From: Amber Willard
Sent: 23 January 2020 16:57
To: Kathryn Block
Subject: RE: Y/100/19/A

Having discussed the application briefly with my manager, we feel the number of flags proposed is excessive, especially as there are a number of other adverts on site.

*ADDITIONAL
- SHOWHOME FLAG
900x1800MM (FLAG)
50x5993MM (FLAG POLE)

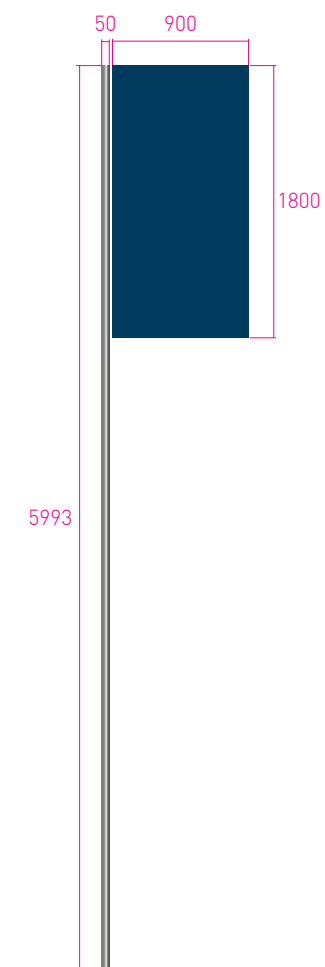
3 flags could be constructed without permission and therefore we would allow 3 however any more we believe will justify refusal due to the impact they cause upon amenity.

Would you be willing to agree to 3 flags? This can be noted within the officers report and wouldn't require further consultation.
